The SAN Day Surgery Redevelopment – Summary of Submissions

Project Application (MP 09_0199)

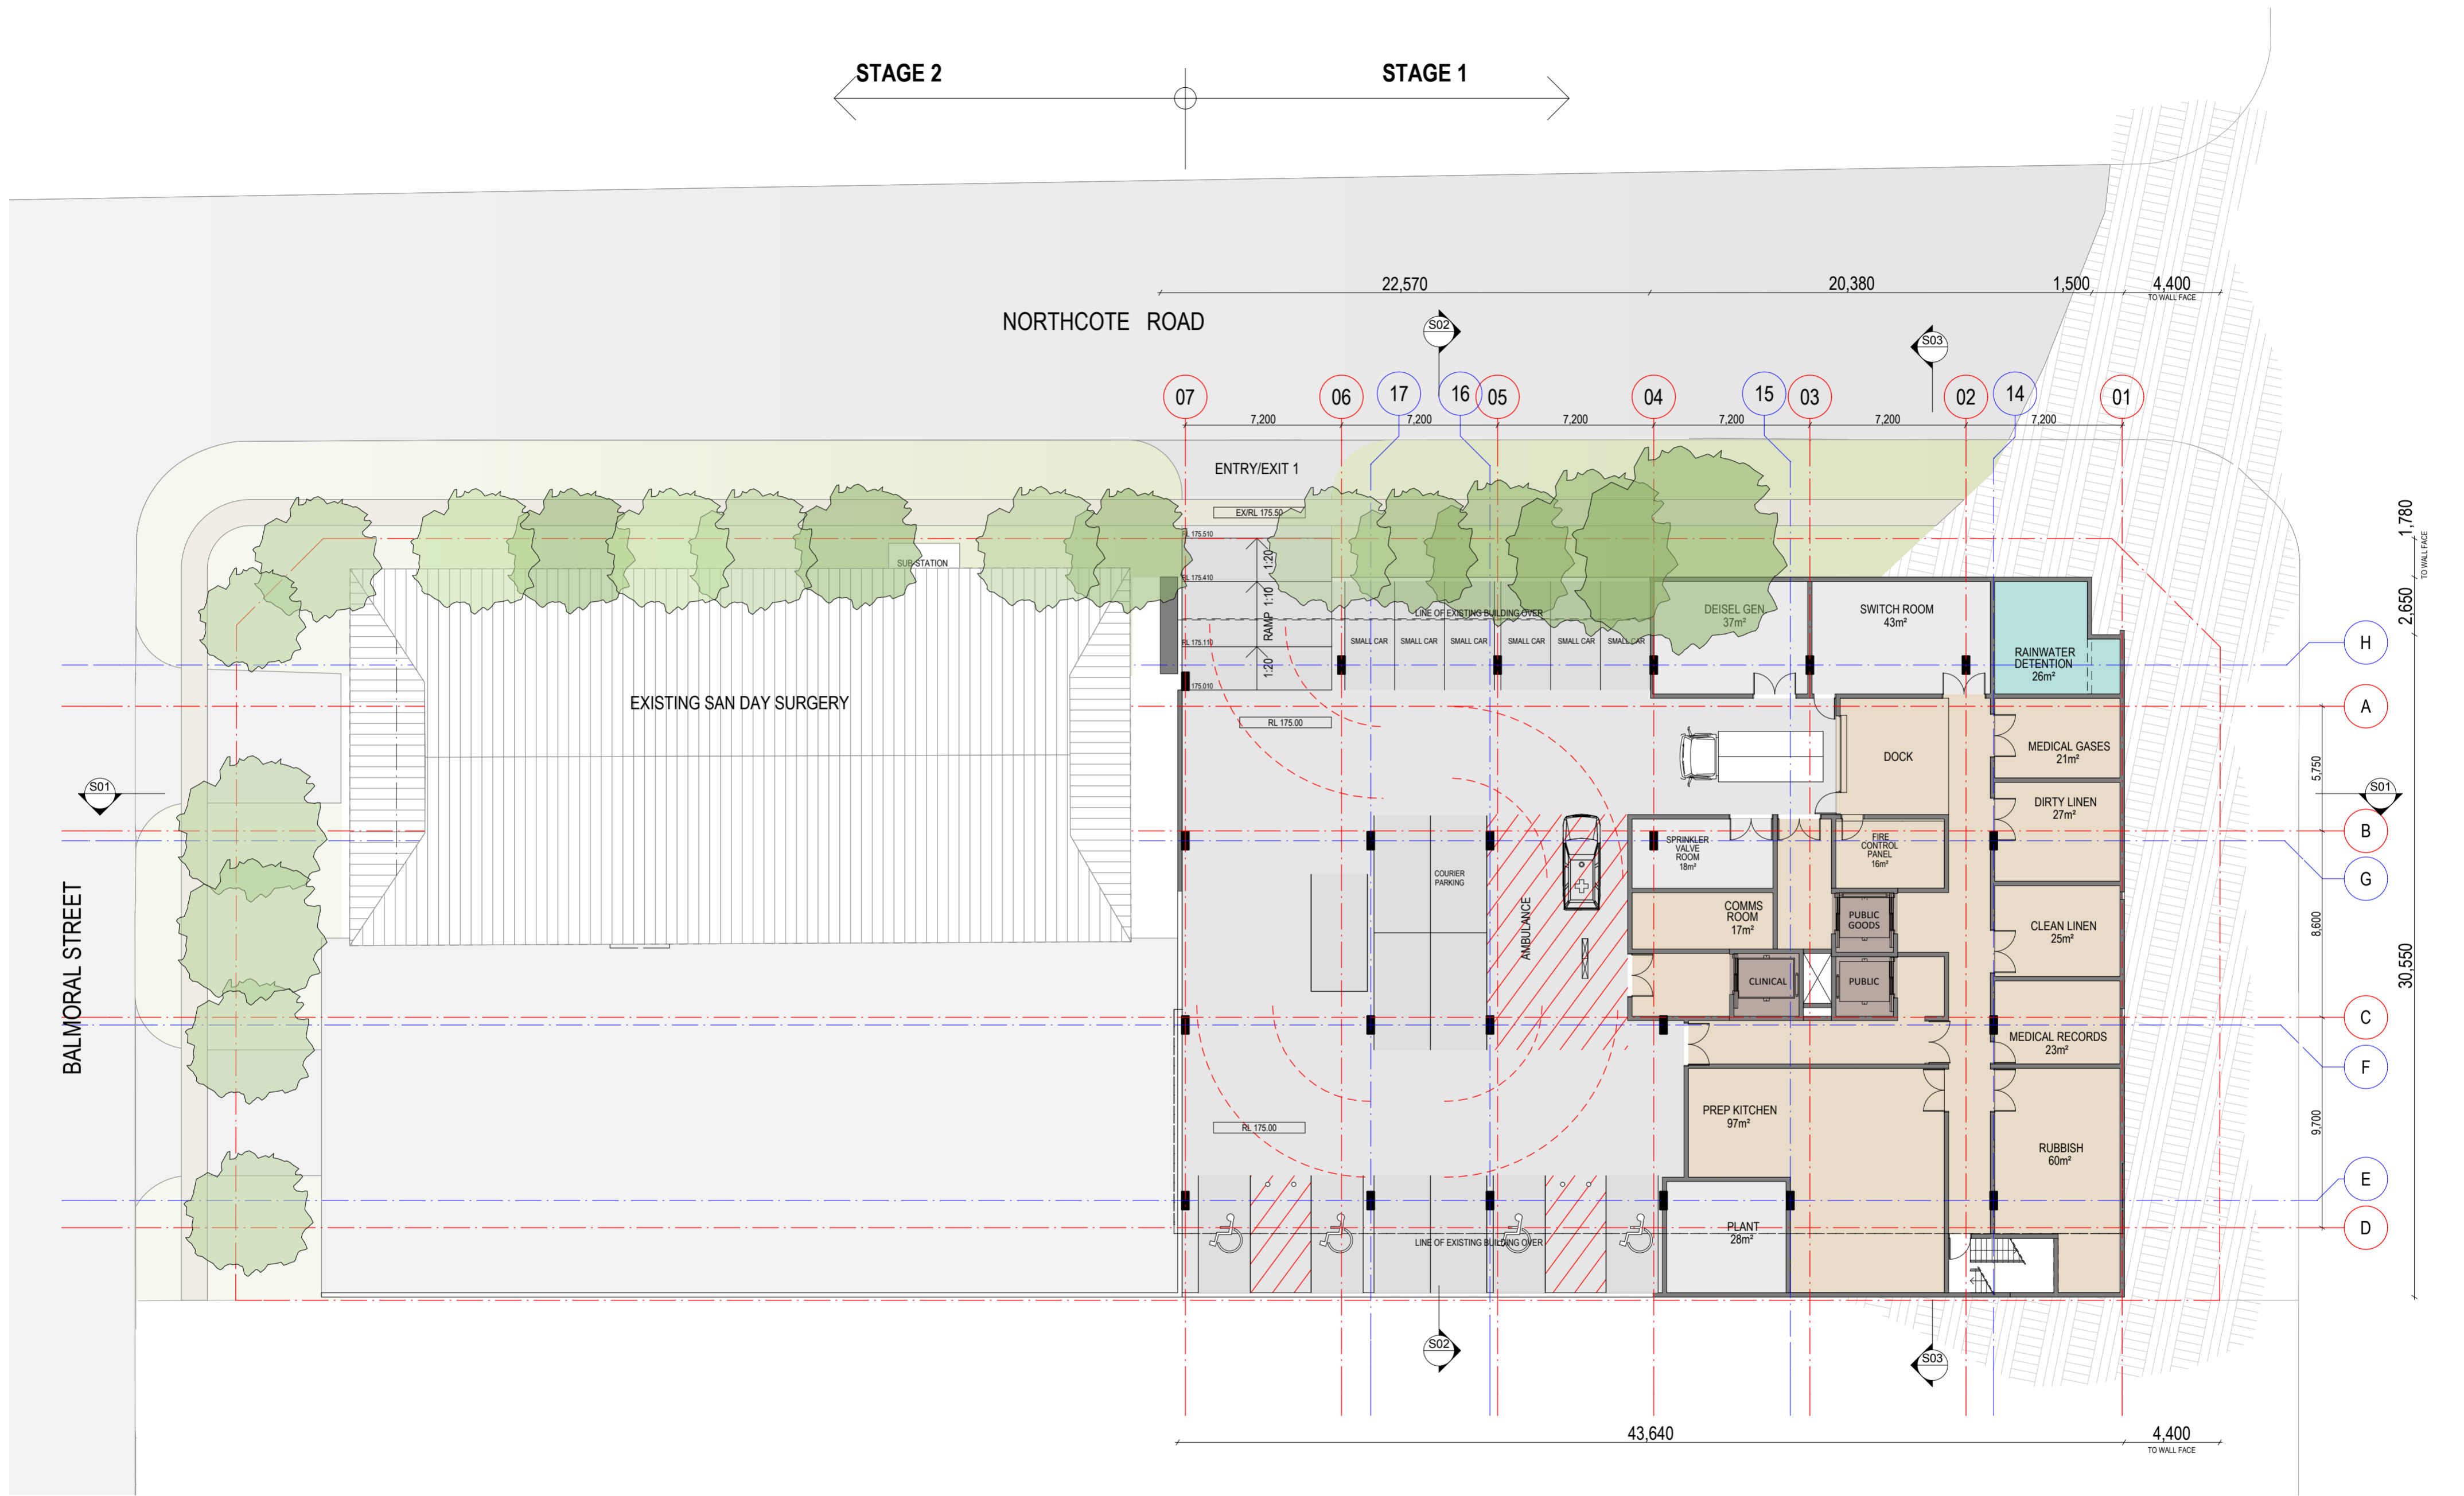
6	The parking provision for both stages 1 and 2 exceeds Council's DCP requirements and is acceptable. Disabled parking and service vehicle provision is also acceptable for both stages. The dimensions of the parking spaces have not been shown and are required. It should be noted that "small" car parking spaces have been provided at a proportion consistent with the ratio of small cars registered in NSW. This is acceptable given that the number of parking space provided exceeds the minimum DCP requirements.	Noted.
7	The development is unlikely to result in an adverse traffic impact on the local road network. The site would generate an additional 33 trips in the am peak and 57 trips in the pm peak which is the equivalent of less than an additional vehicle a minute.	Noted.

Issues Raised		Proponent Response
	The traffic consultant has apportioned the flows to surrounding road network and demonstrated that the intersections would continue to operate at acceptable level of service and degree of saturation.	
8	<p>The matters should be addressed should the Department approve the Project Application:</p> <ol style="list-style-type: none"> 1. Driveway widths need to be specified and vertical easements provided on all driveways in accordance with AS2890.1. 2. The direction of the driveways in Balmoral Street needs to be reversed so that the exit driveway is furthest from the intersection, giving more time for exiting motorists to gauge vehicle approach speeds. 3. The dimensions of parking spaces must be shown and exclude support columns. 4. Vertical clearance for service vehicles must be 3.5 metres in accordance with AS2890.2 – Off- street commercial vehicle facilities. 	Noted. Revised plans have been prepared which include the requested additional information and reverse the direction of the driveways (see Appendix C). Further, included within the final Statement of Commitments are requirements to design and construct the layout of the car park in accordance with AS2890.1 and AS2890.2.
